Application No: P/155/21/RES
Site Address: Land West of Pagham Road Pagham
Description of works: Approval of reserved matters (layout, scale, appearance and landscaping) following outline consent P/140/16/OUT for the 'local centre' parcel which comprises of retail, community and commercial uses, 20 No residential apartments and a 70 bed care home.

Thank you for your internet representation made on 1st April 2022 which has been recorded as an objection with the comments as follows:

PROPOSED DRAINAGE STRATEGY

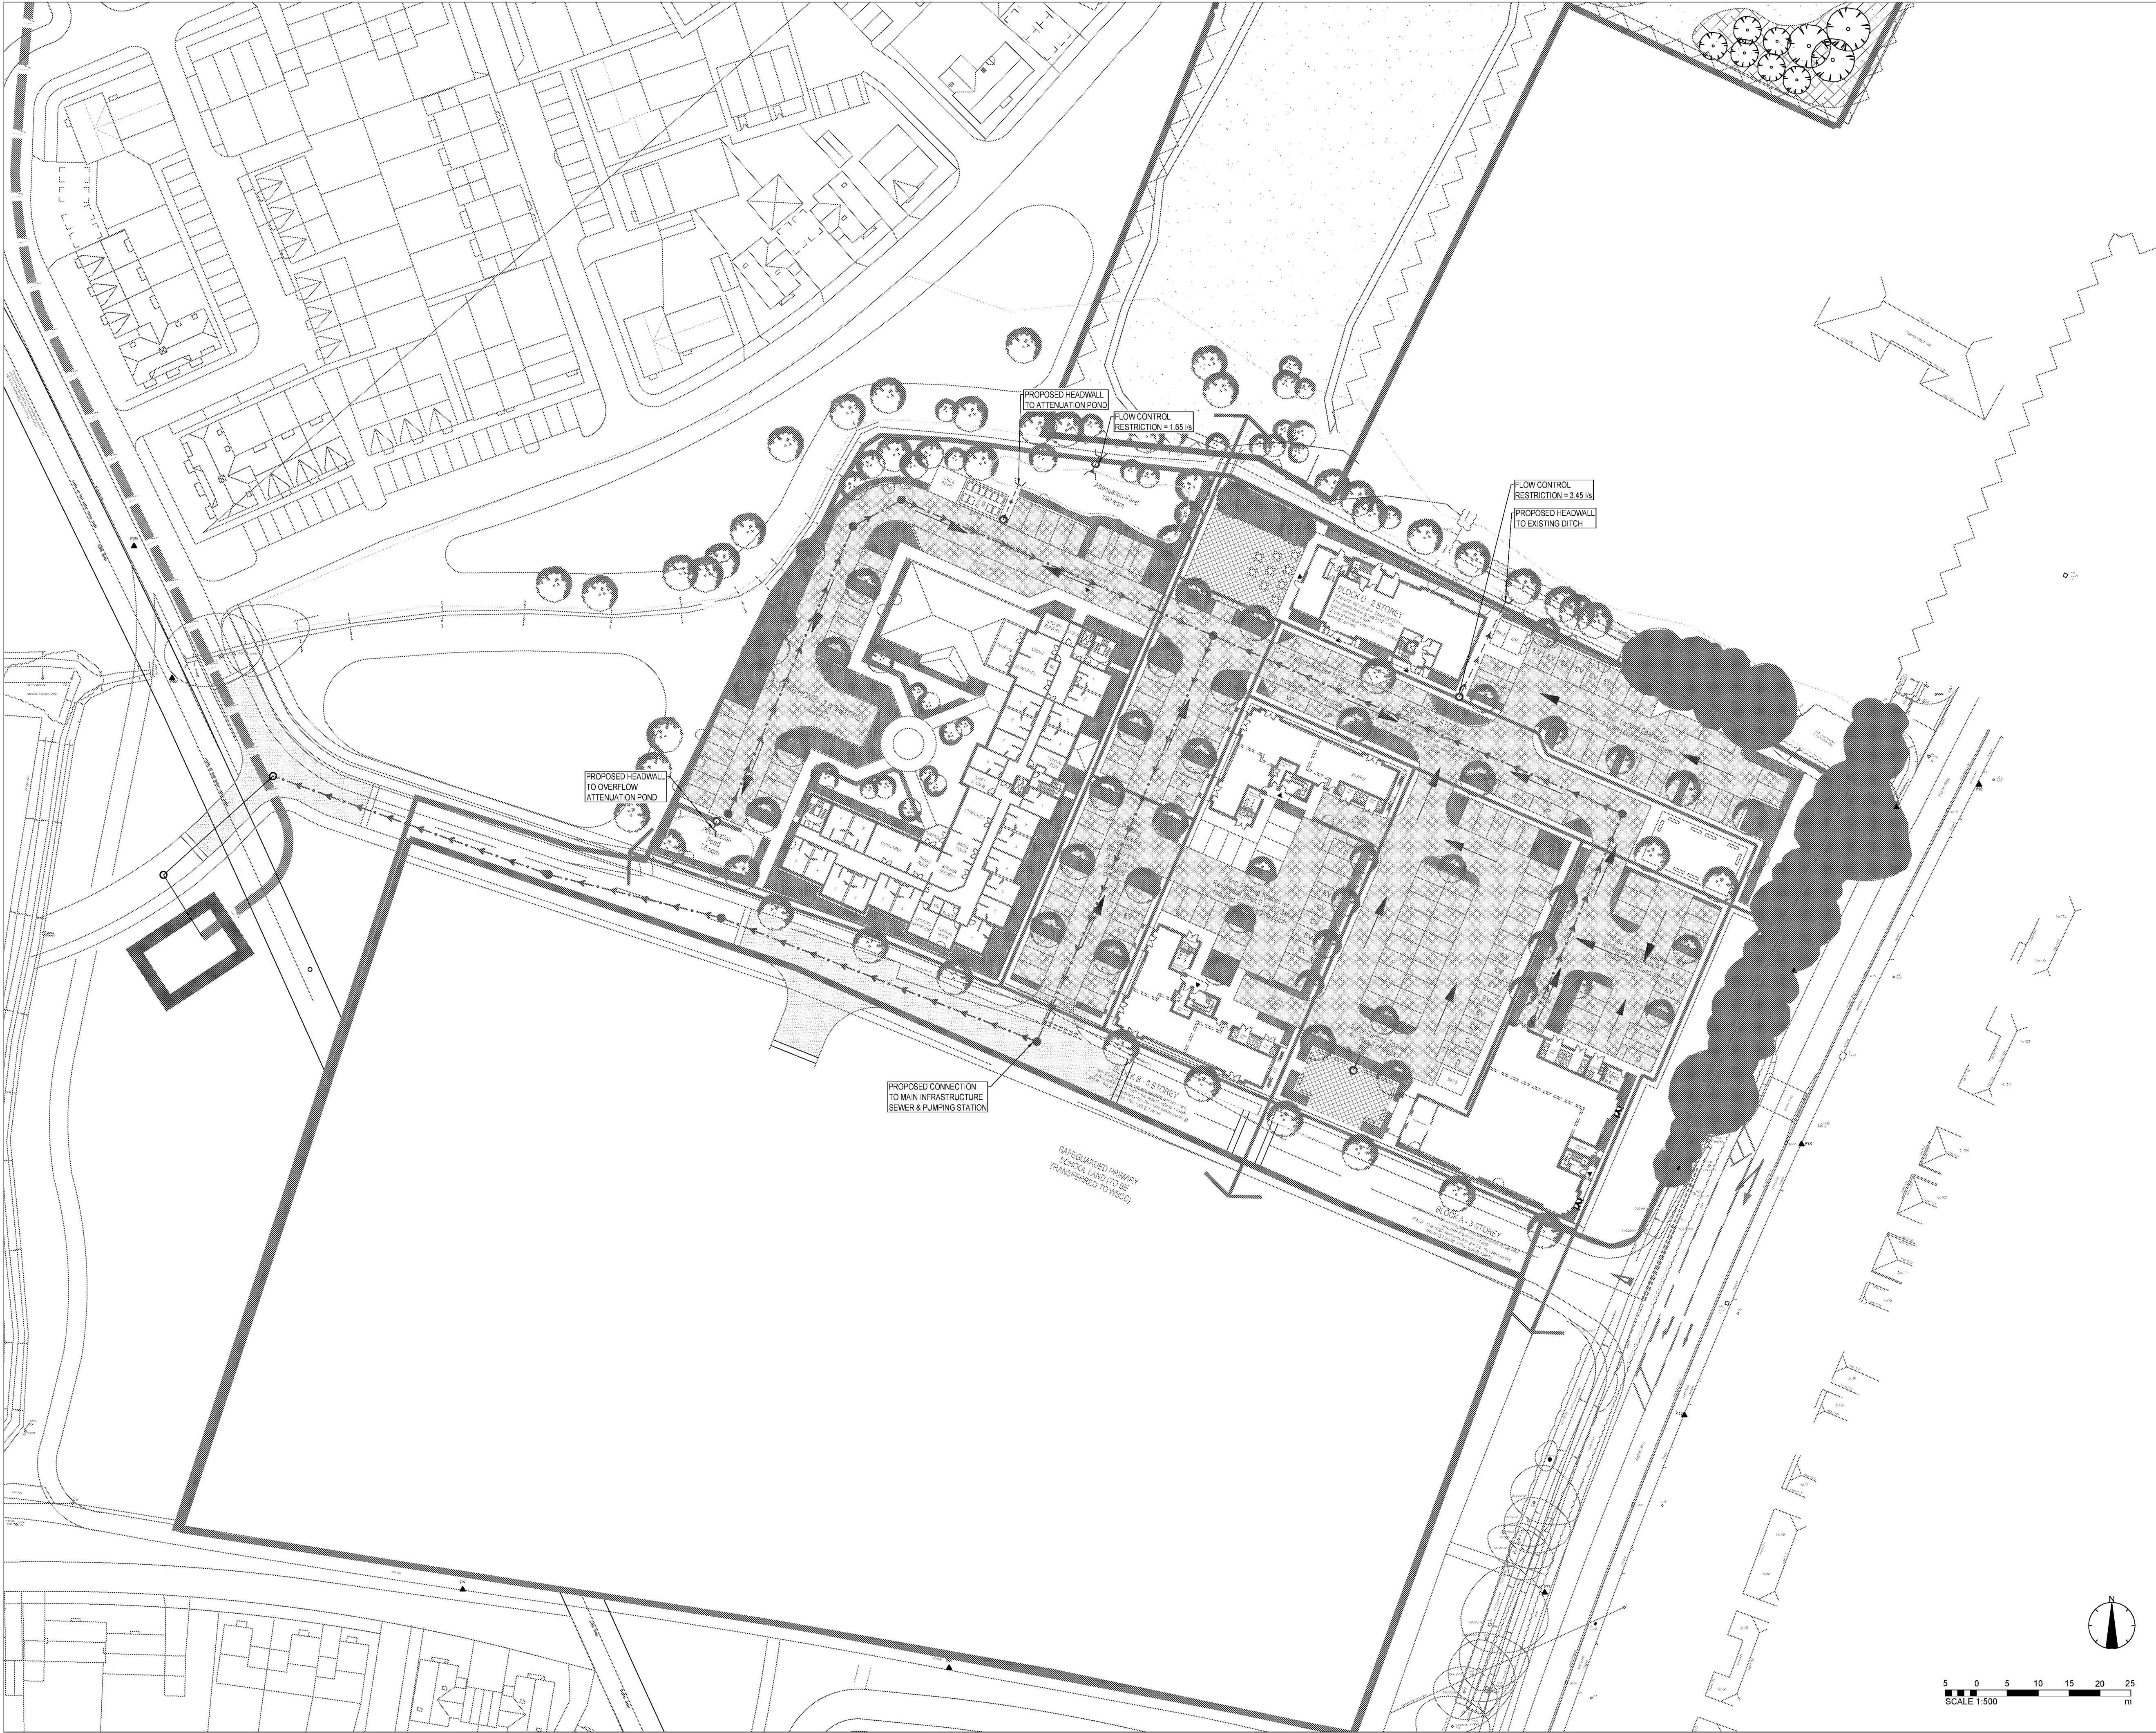
I've also read the proposal from the developers of how they plan to mitigate the displaced water from site and can safely say that their proposal cannot work.

They seem to be under the impression that the drainage ditches on the land and adjacent fields are functional and flow to the rife water course. I need to assure you that they do not.

The ditches have never been maintained properly save a flail cut on rare occasions with the cutting's being left to further block the ditch floor.

There are various culverts along the ditch lines and all are non functioning due to the continued build up of silt within them. These would all have to be attended to and the ditches dredged. Plus the ditches peter out further down the fields and would need to be renewed to the rife in order to work.

If that isn't done then the excluded water from the development will have to find somewhere else to go so that will mean flooding risk to other properties.
